Online Comment

Application H09-0339-26
Location 36 West End Holbeach Spalding PE12 7HA
Proposal Change of use from an MOT testing station, vehicle repair garage and petrol filling station to a flexible (Class Sui generis) commercial unit, while retaining the petrol filling station use

Name Greg Watkinson
Address Conservation Officer

Date Submitted 07-05-26
For/Against Comments

Proposed front elevation

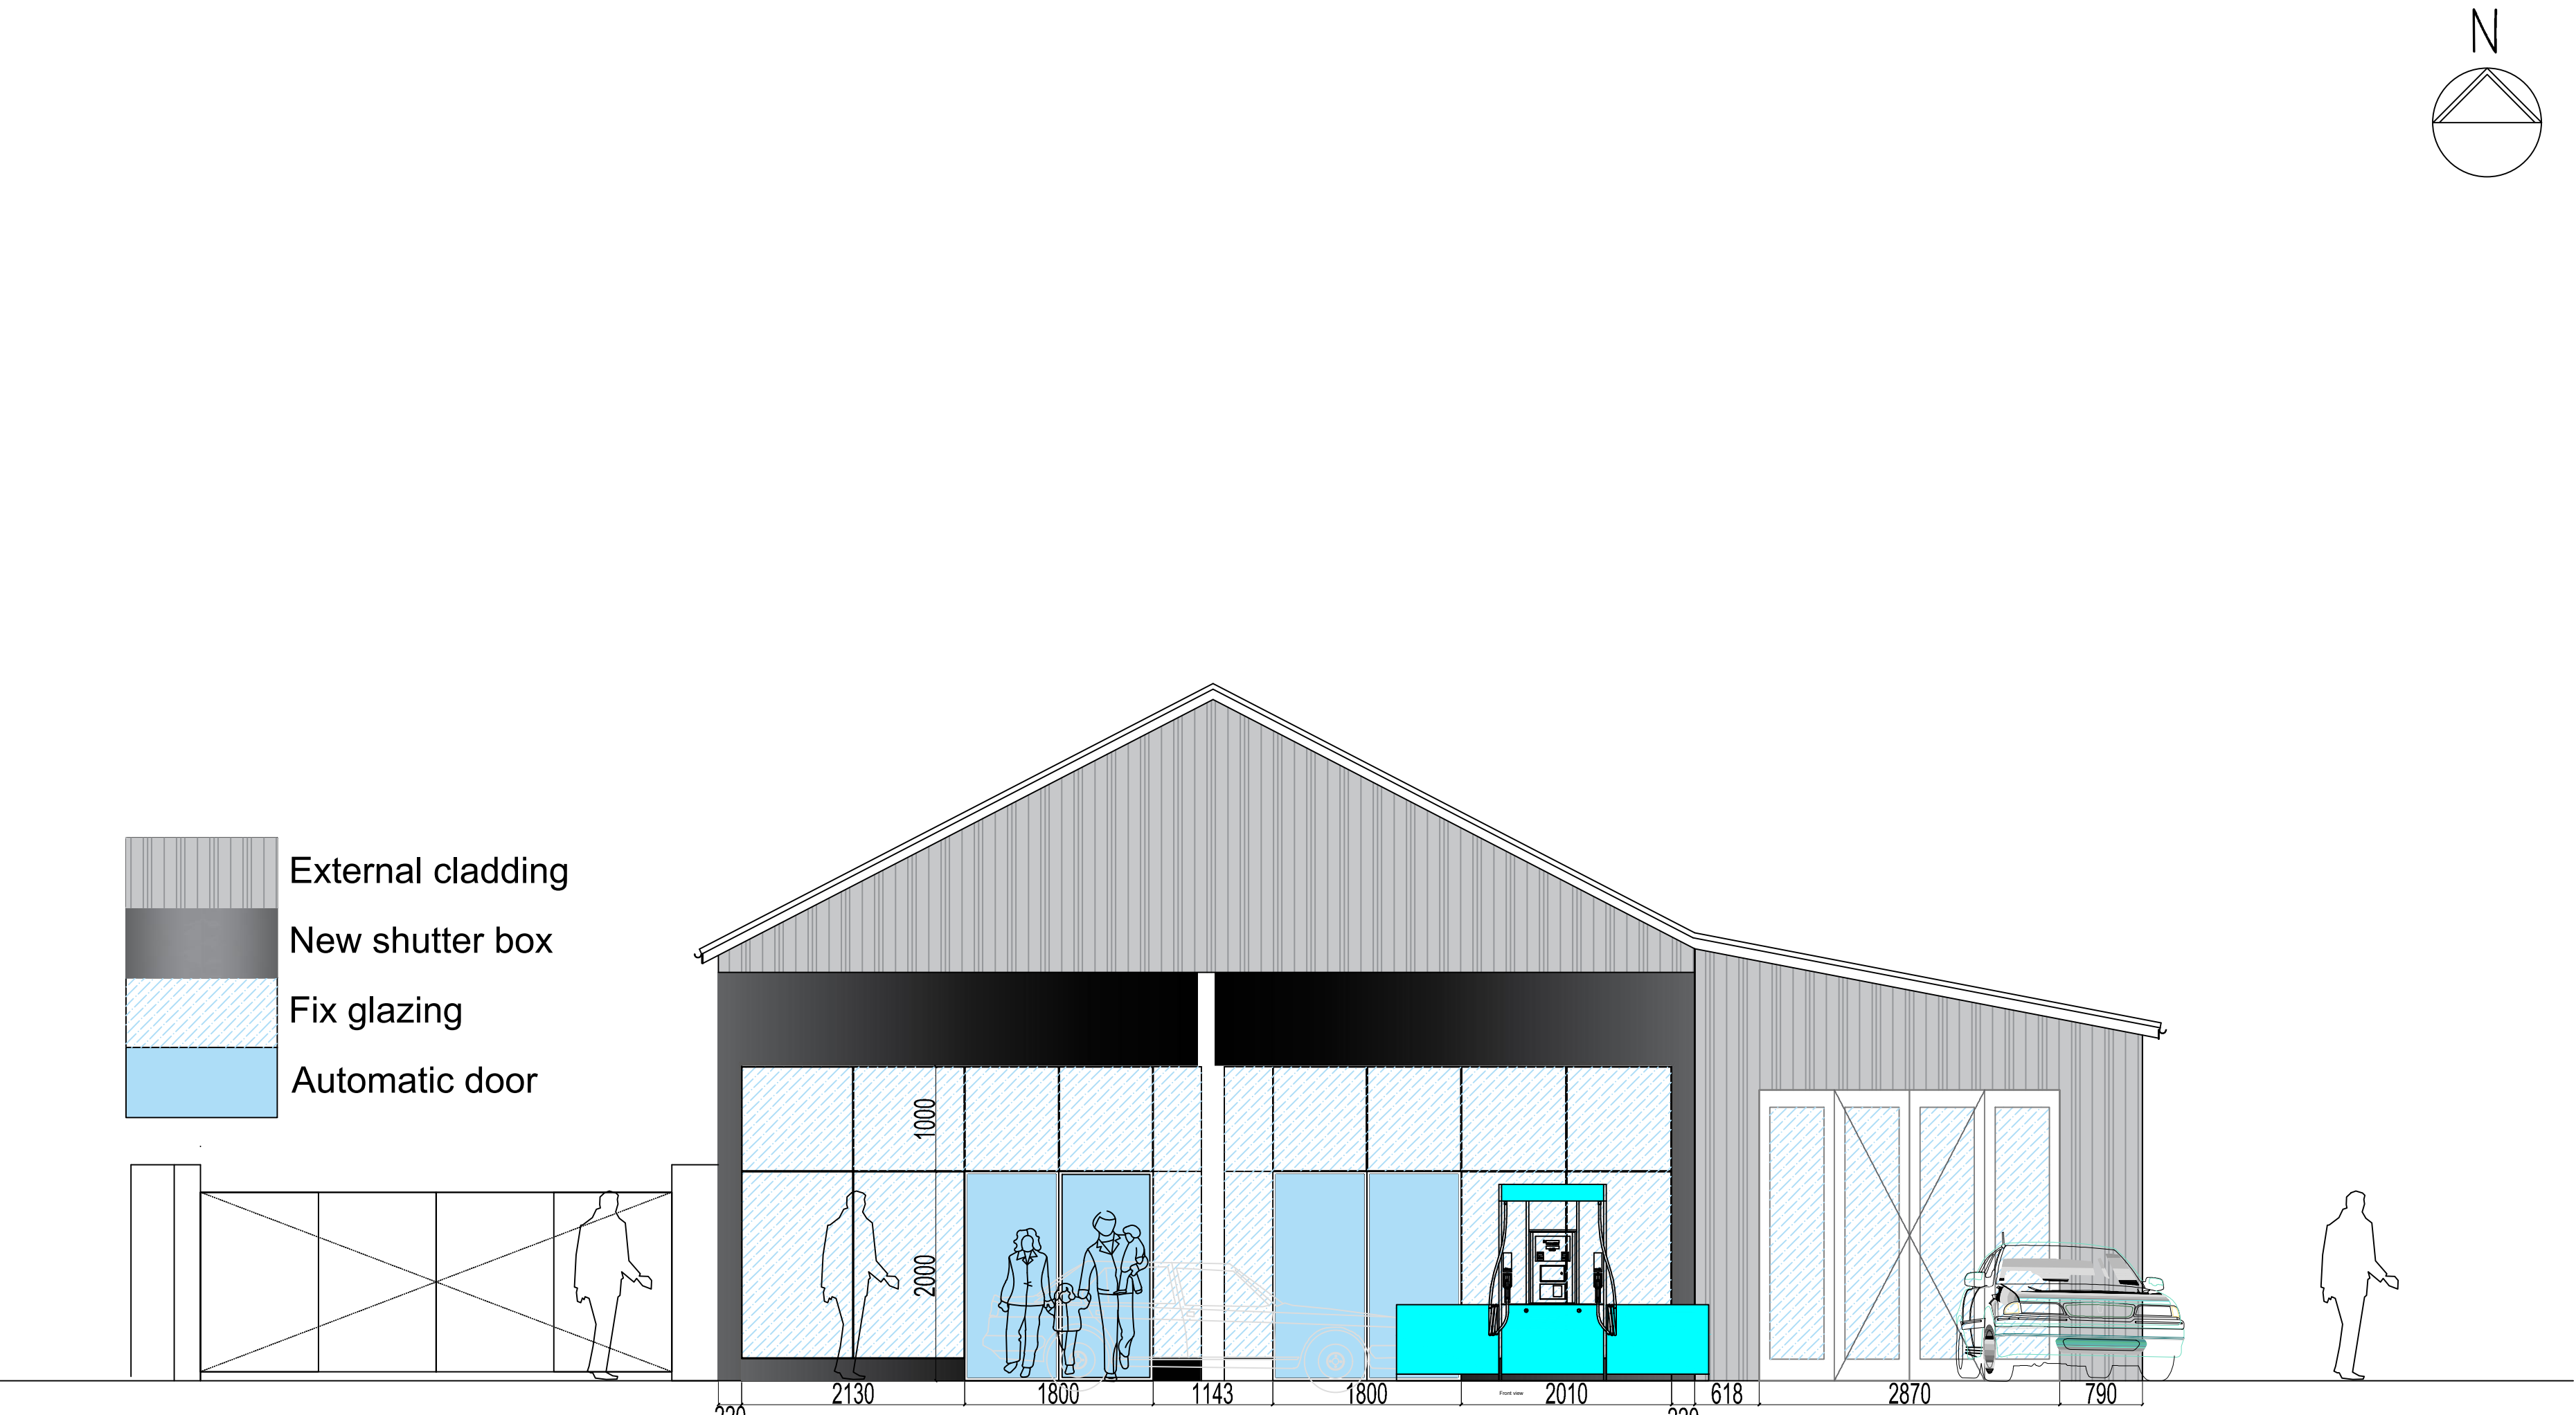
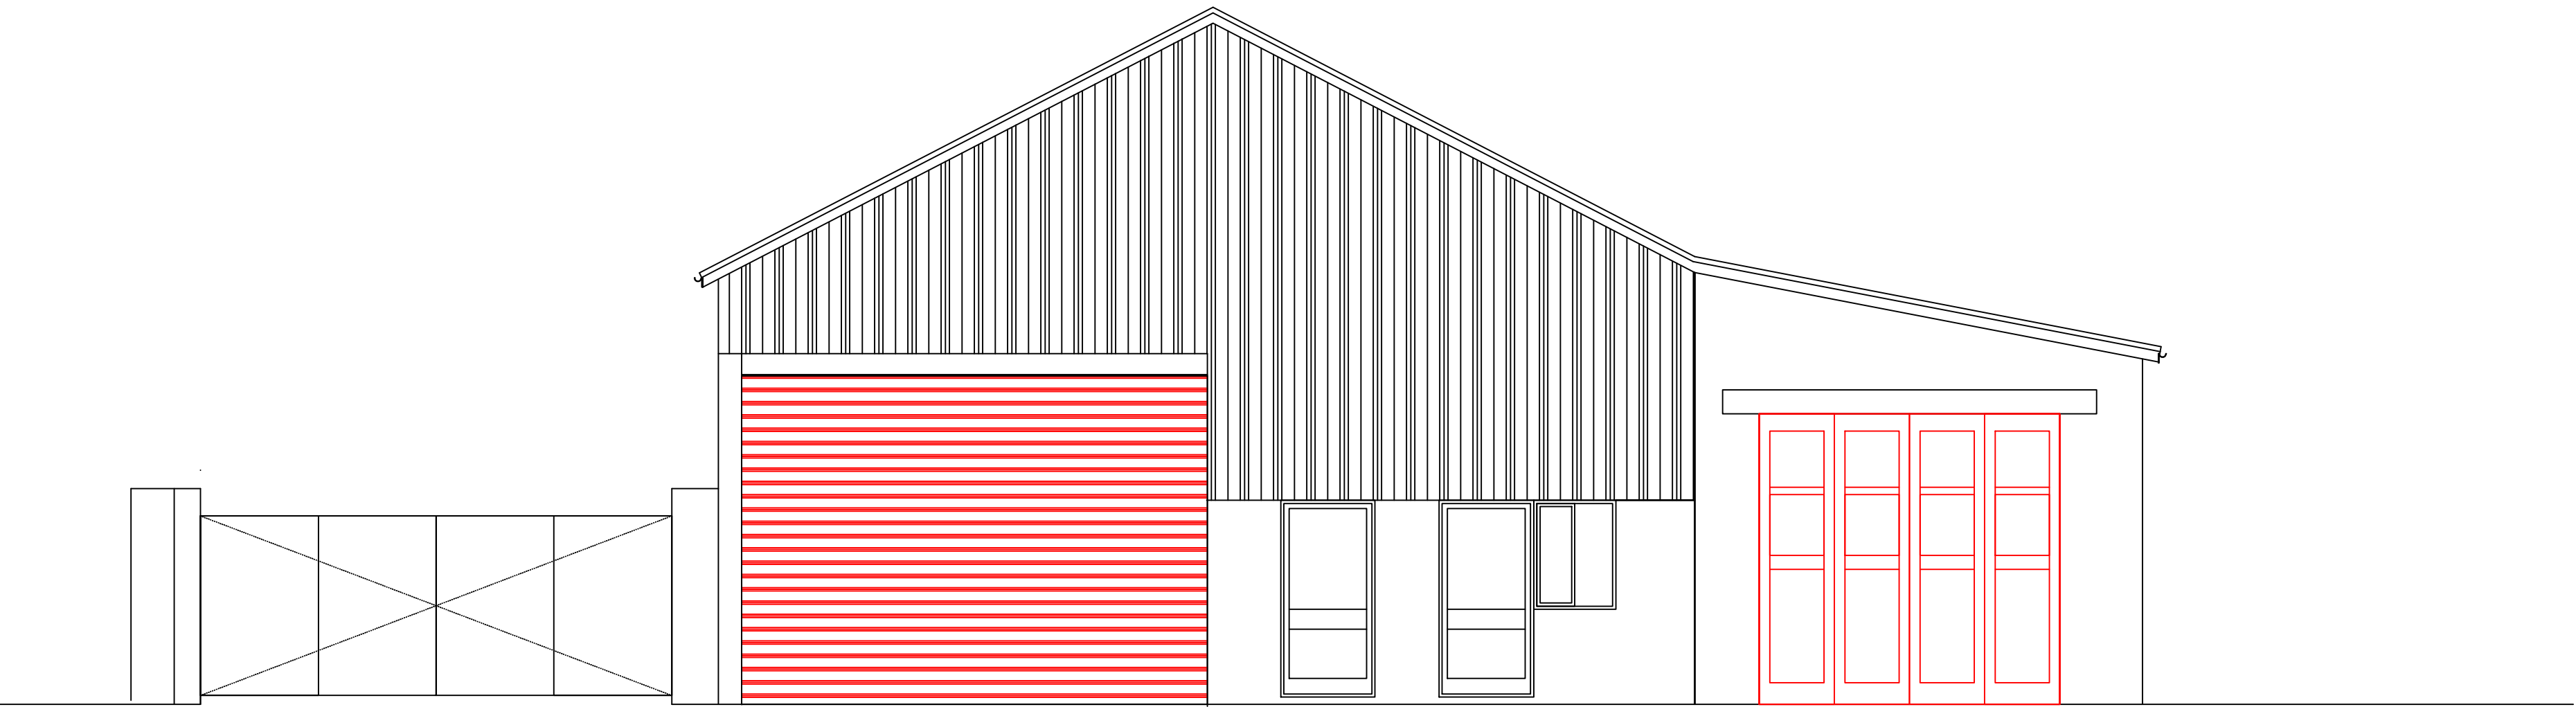
The application contains several aspects which would not typically be acceptable in a conservation area setting (i.e. grey external cladding, box shutters etc) however, a site assessment shows that there is additional context which mitigates against these arguably harmful aspects. Namely, the site as extant is itself an eyesore, and whilst it is proposed to retain the relatively functional looking building, in a poor state of repair and is therefore considered an eyesore in the immediate area. As a result, the proposed works, which would result in a modernised and tidied appearance would represent a neutral, possibly even positive effect upon the CA, even though the proposal contains aspects which, in typical circumstances, would not be considered appropriate. In this instance, the proposal can be considered to assist in conserving and/or enhancing the historic environment.

However, having said that, should you be minded to approve the application, I would recommend imposing a condition that requires the submission of the details of the proposed box shutters. This is because an overly prominent box shutter would appear out of sorts and incongruous. The applicant should be minded that any shutter storage should be as discreet and low profile as possible.
